A57 Link Roads

TR010034

**9.25 Statement of Common Ground with
Derbyshire County Council**

**Table 3.1: Statement of Common Ground (SoCG) Between National Highways and Derbyshire County Council (DCC)
 Table of Issues/Matters - Final Version dated 27 April 2022**

**6.5 Environmental Statement  
Appendix 6.2 Archaeology Scope of Works and  
Written Scheme of Investigation**

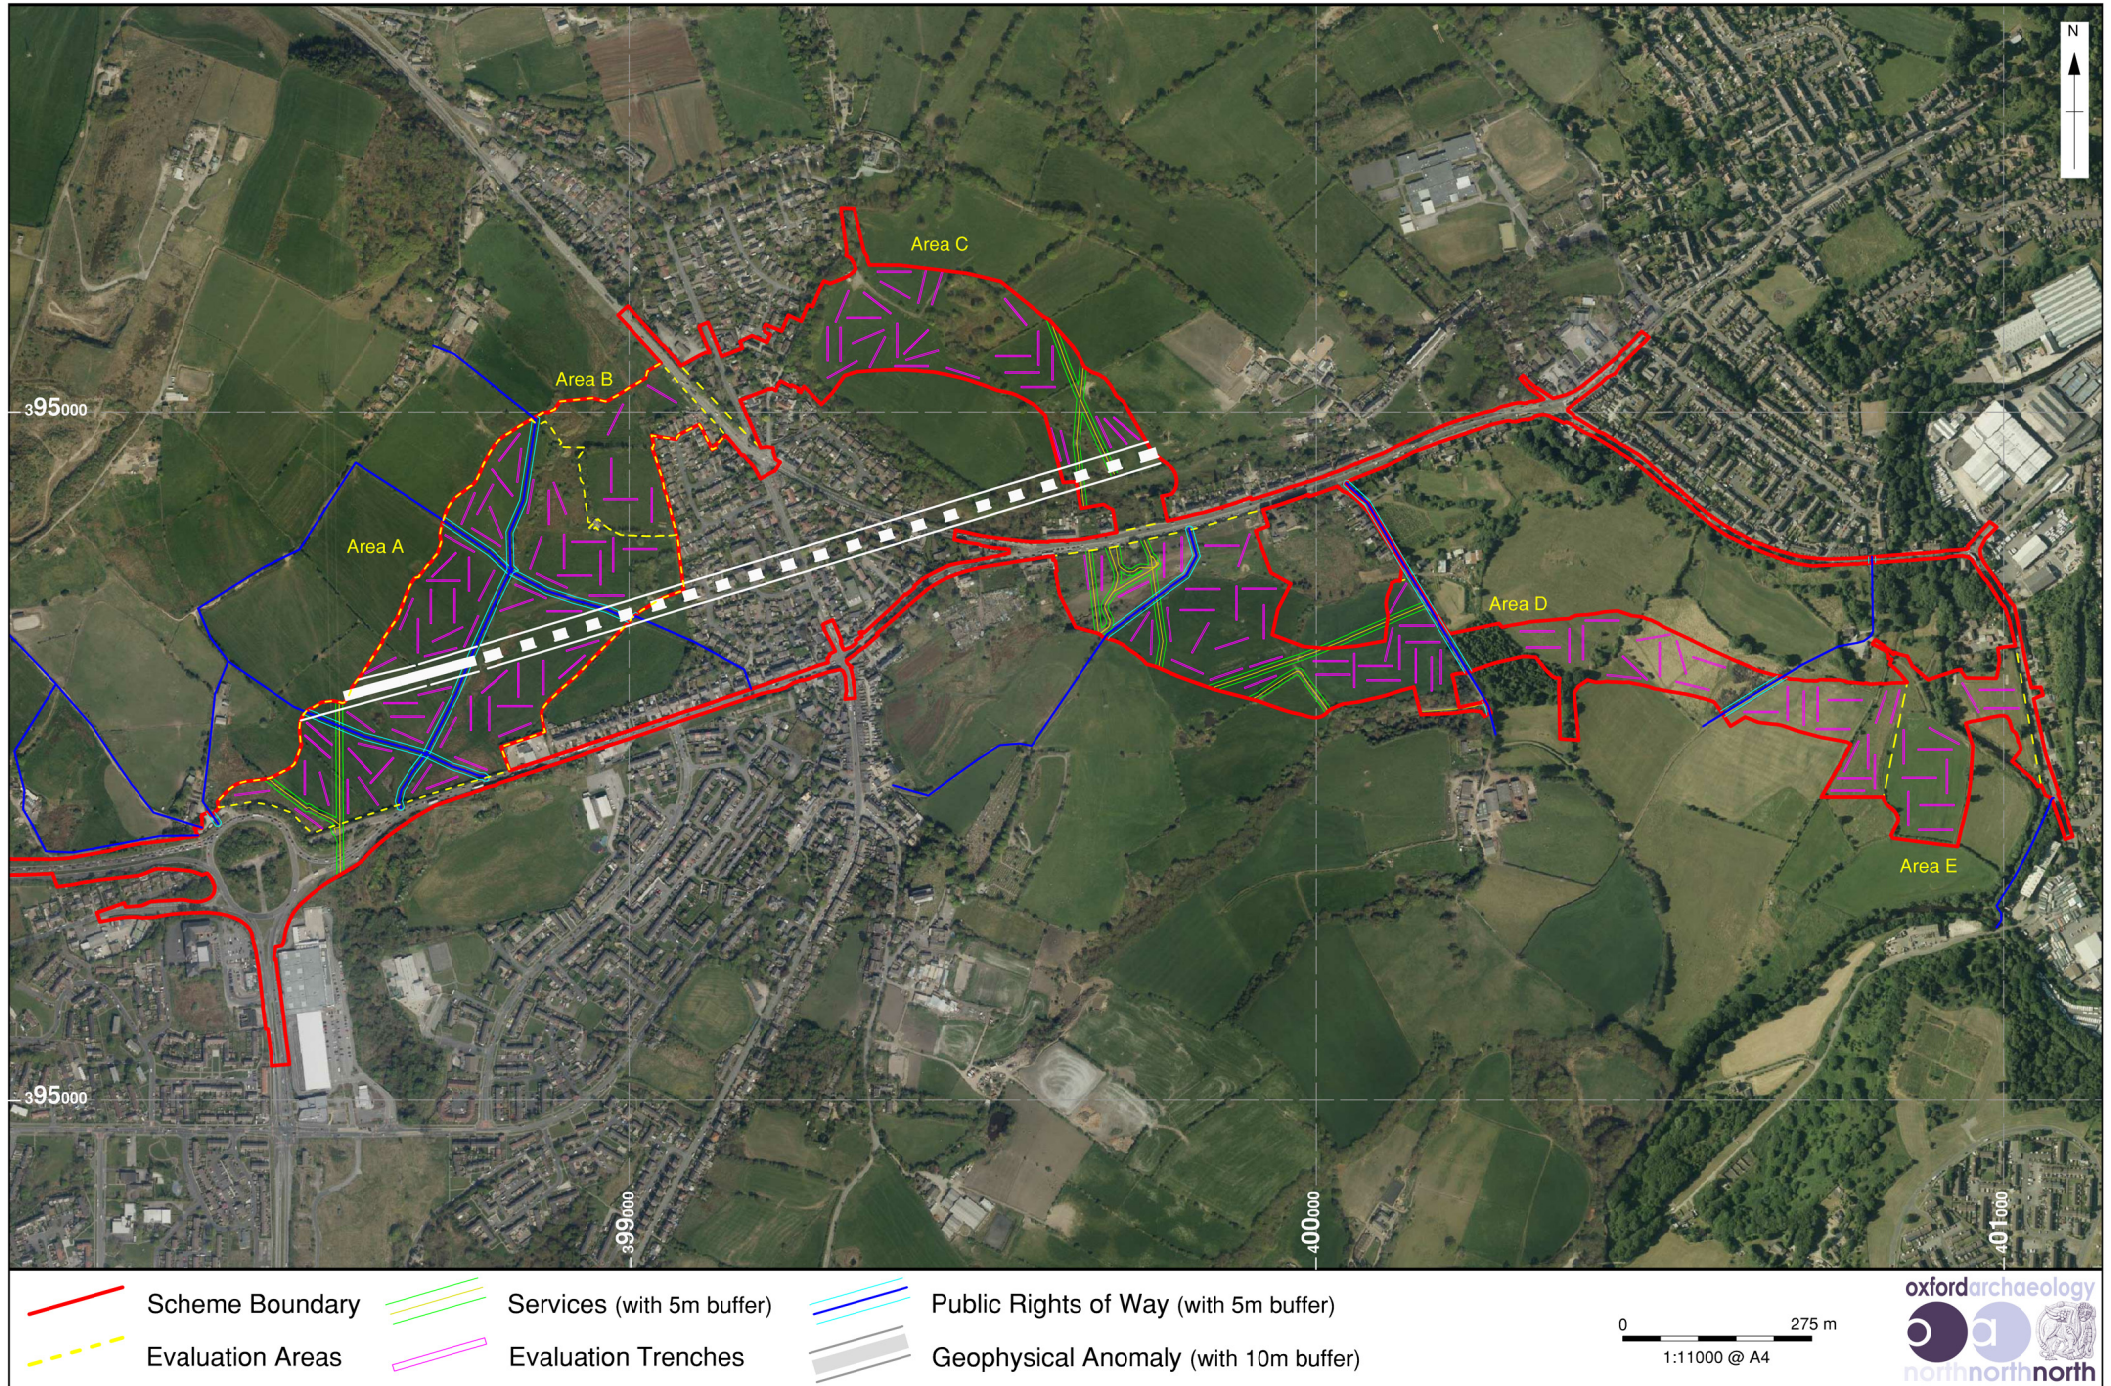
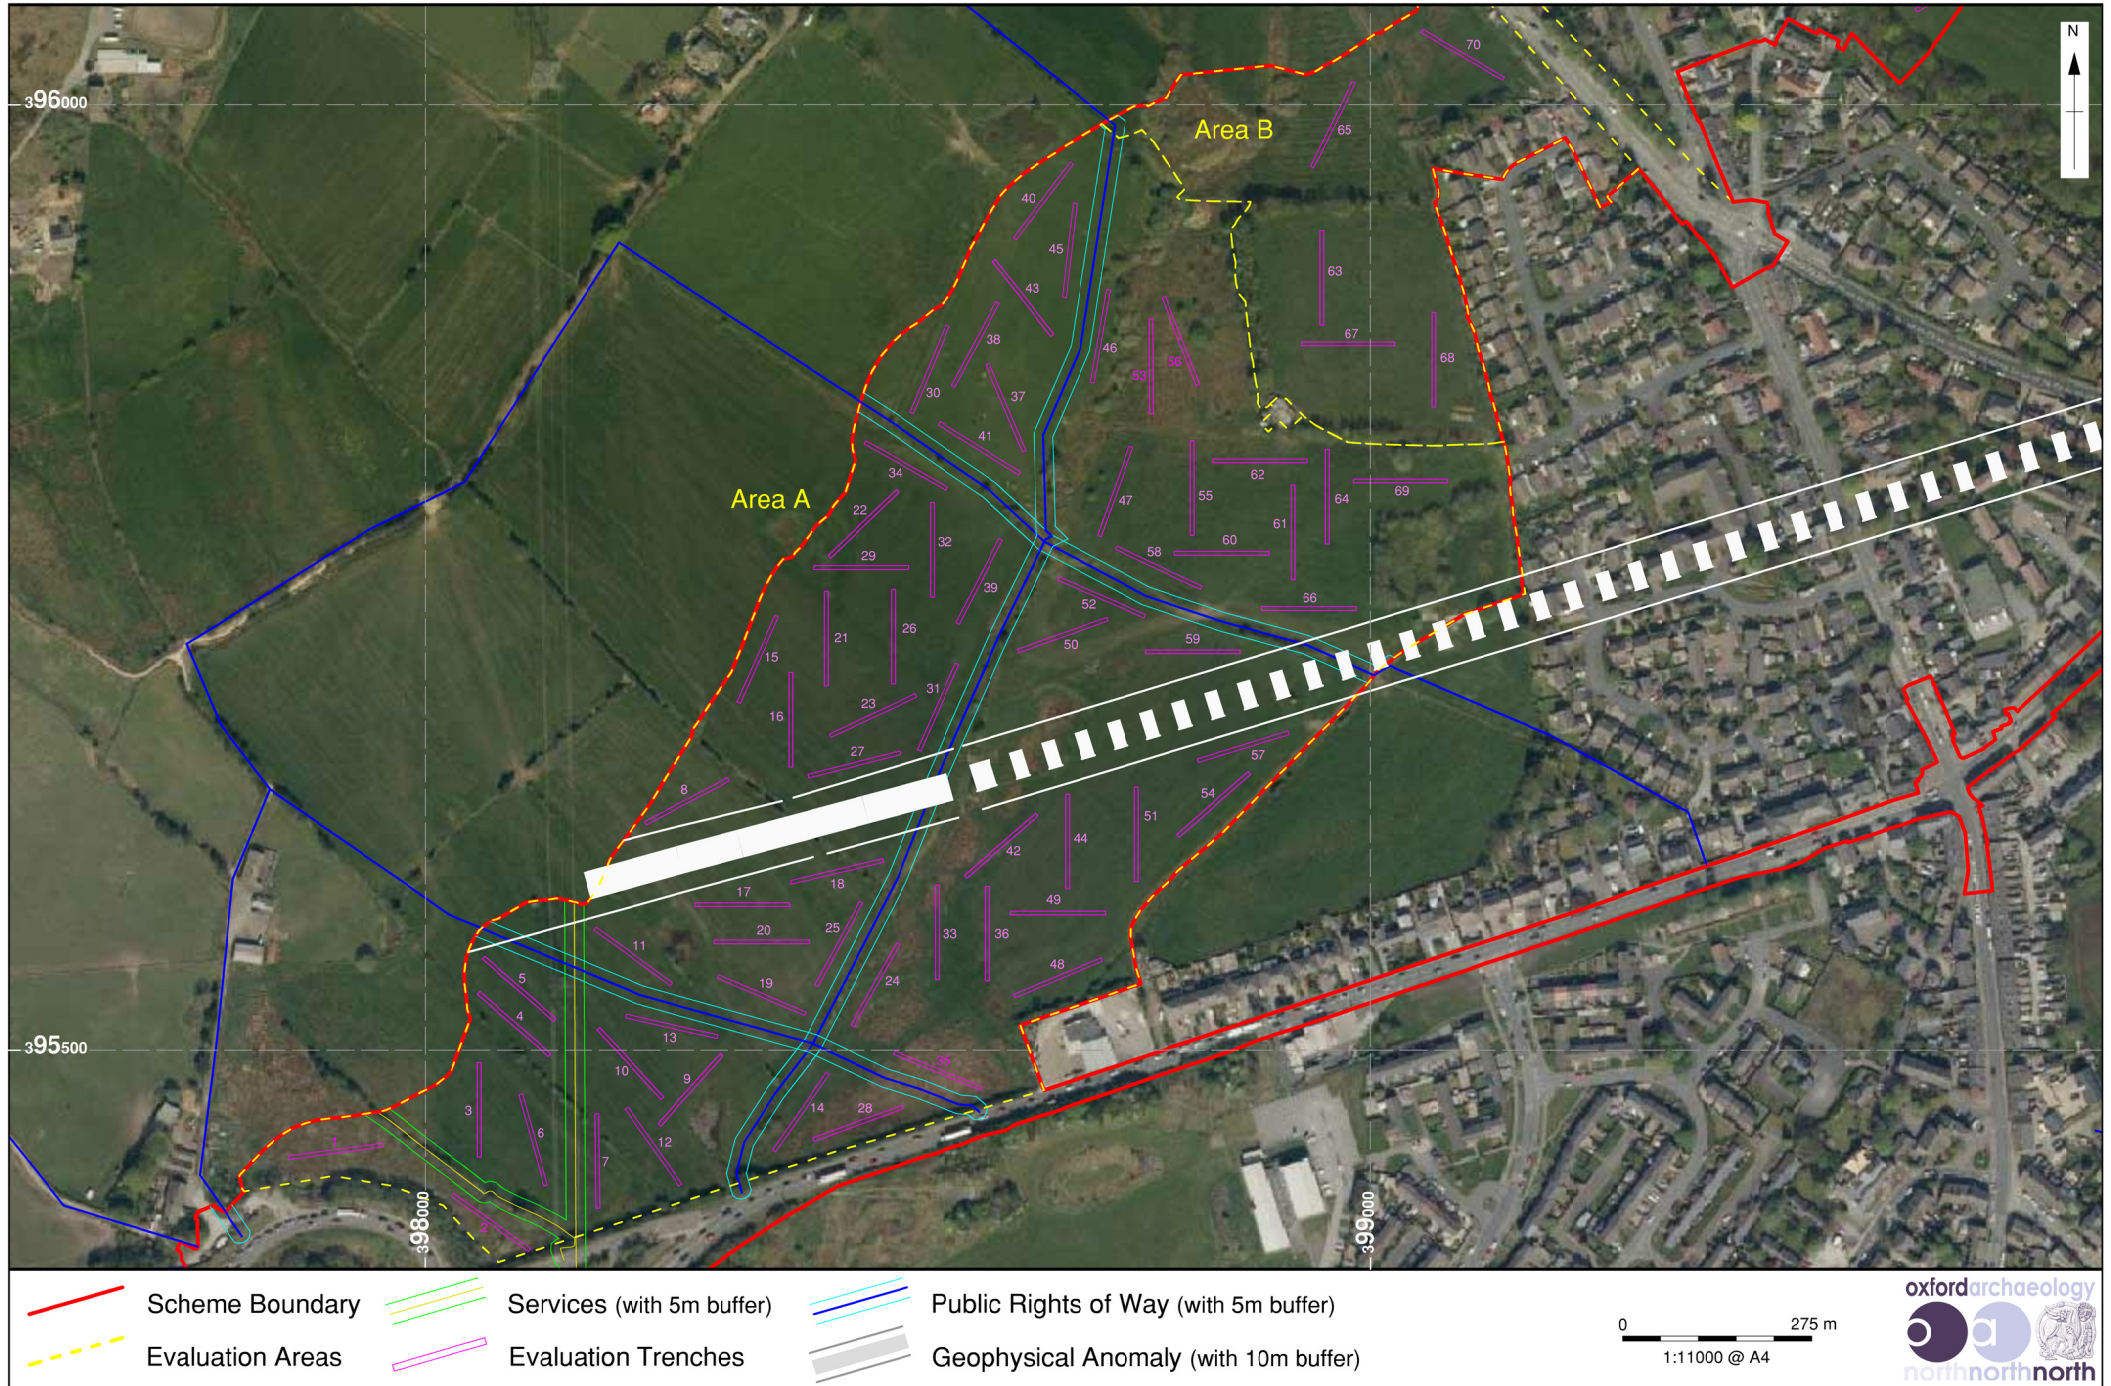
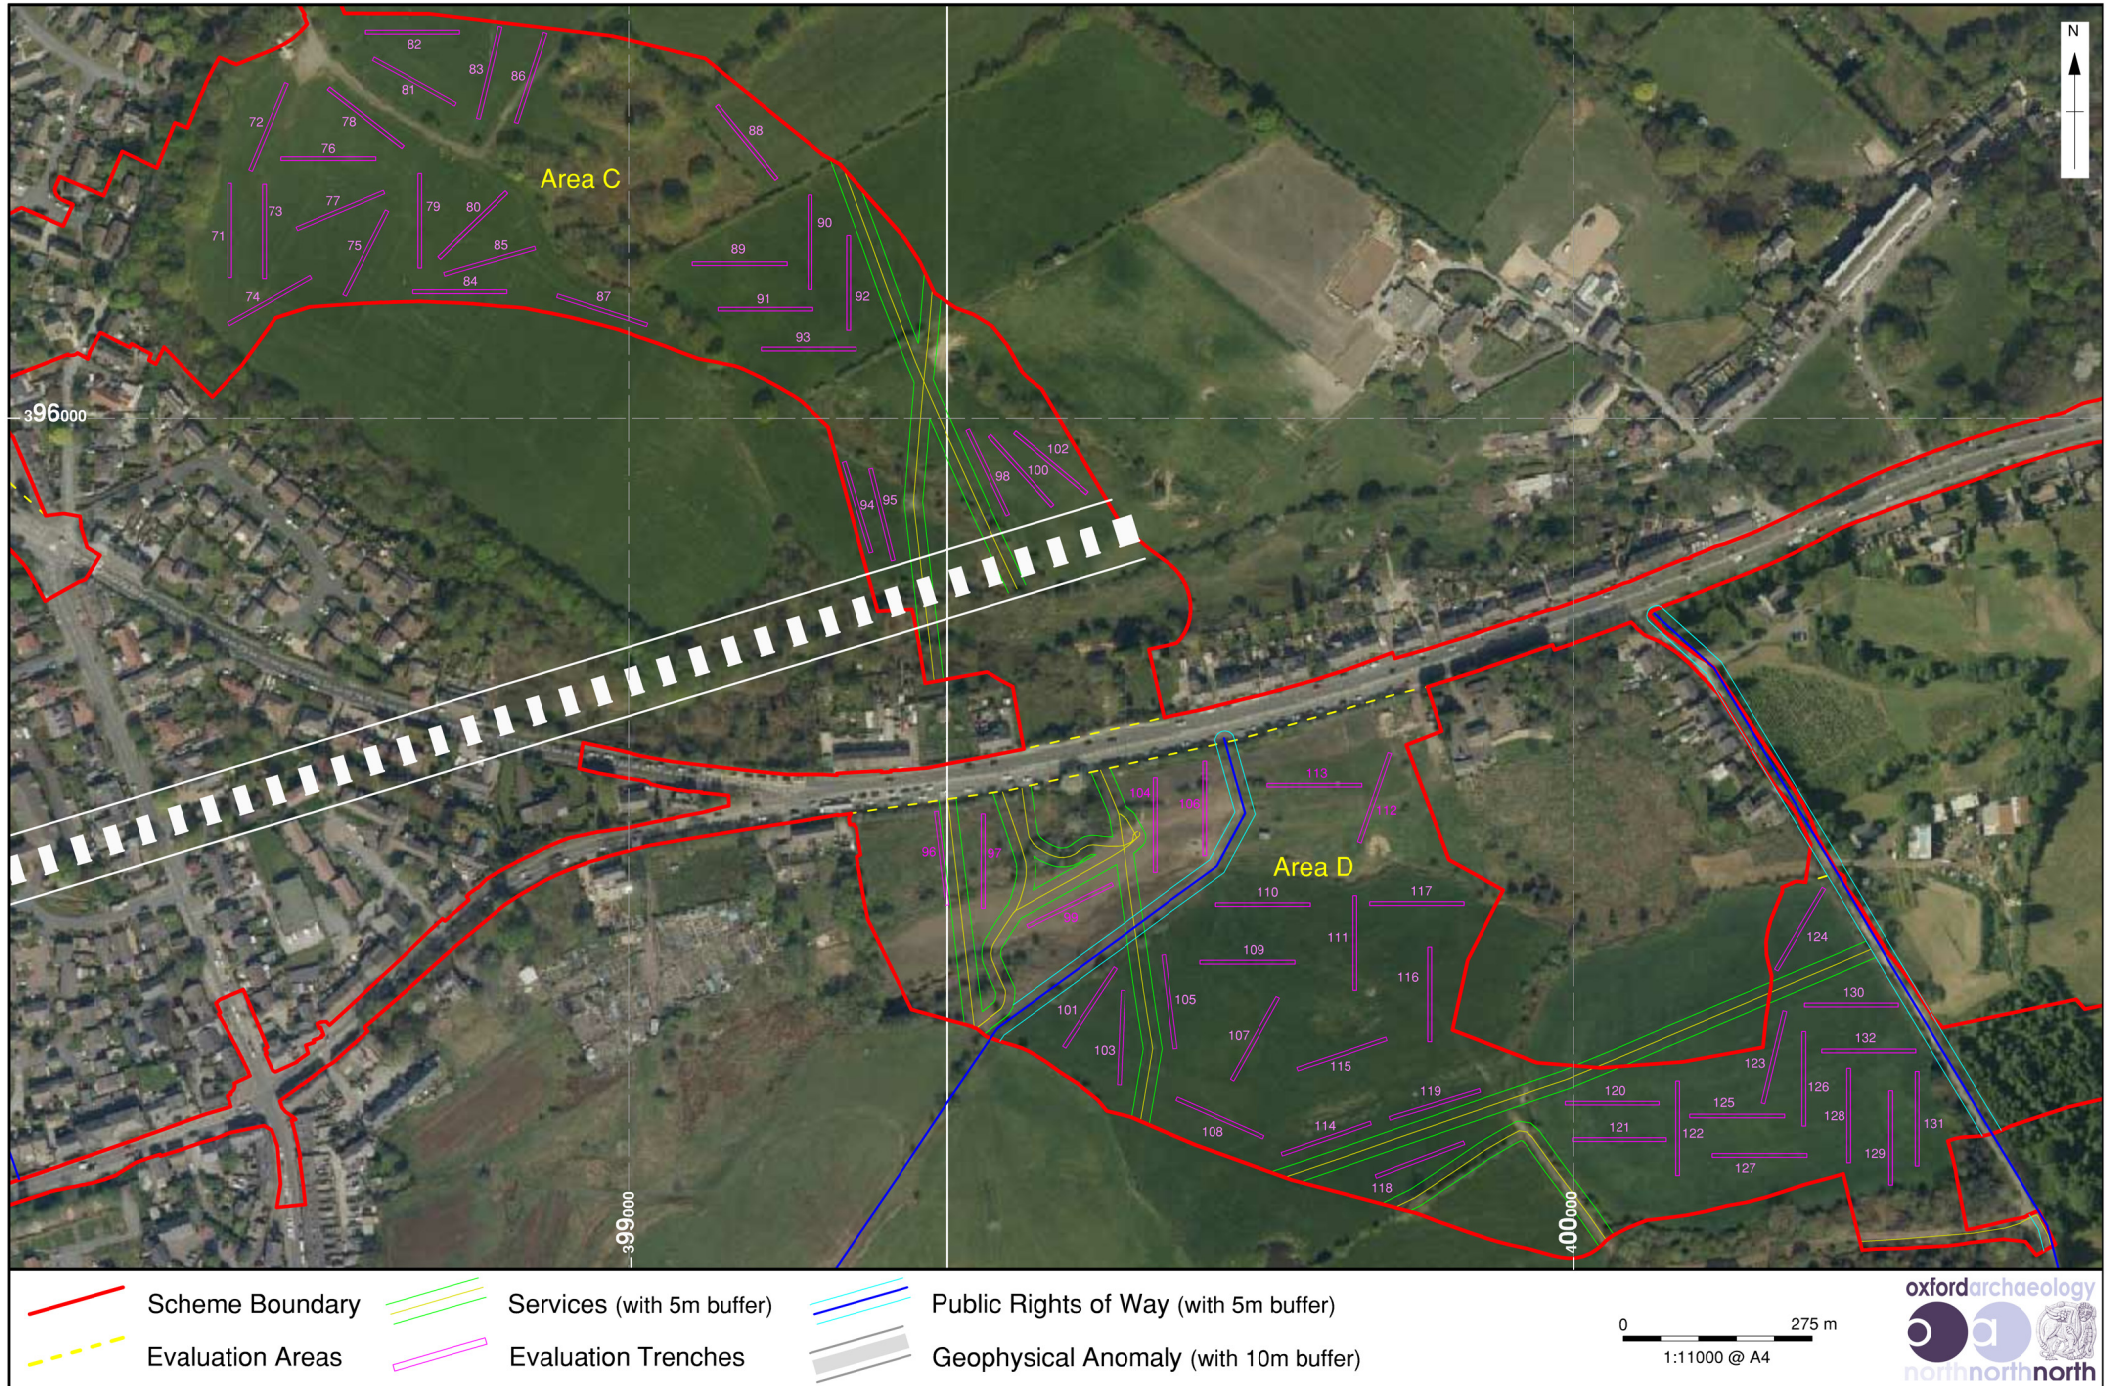
SoCG Ref. Number	Relevant examination document	Relevant Issue	DCC Comment	National Highways response	Status
3.1	Environmental Statement (ES) Chapter 6 – Cultural Heritage [APP-062]	Archaeology & Cultural Heritage Methodology Archaeological investigation scope - Derbyshire	The Consultee queries why the Applicant is only allowing for “pre-DCO application archaeological investigations within the extent of Tameside Metropolitan Borough” as the archaeological risk is the same on either side of the River Etherow in this area. It recommends that the Derbyshire side of the Scheme is included in investigations.	Derbyshire has also been accounted for within the pre-DCO works and the methodology and Written Scheme of Investigation have been formally approved by Derbyshire CC’s representative.	Agreed

3.2	Environmental Statement (ES) Chapter 6 – Cultural Heritage [APP-062]	Archaeology & Cultural Heritage Methodology Archaeological investigation scope - Derbyshire	The Consultee states that the assessment of cultural heritage significance and impacts will require a phased approach at the EIA stage, involving desk-based study and site-based field evaluation as appropriate. It advises that field evaluation would typically proceed from an understanding of geo-archaeology and may then comprise geophysics in accessible areas, supplemented by trial trenching where appropriate.	This approach has been agreed in consultation with the Derbyshire CC’s representative.	Agreed
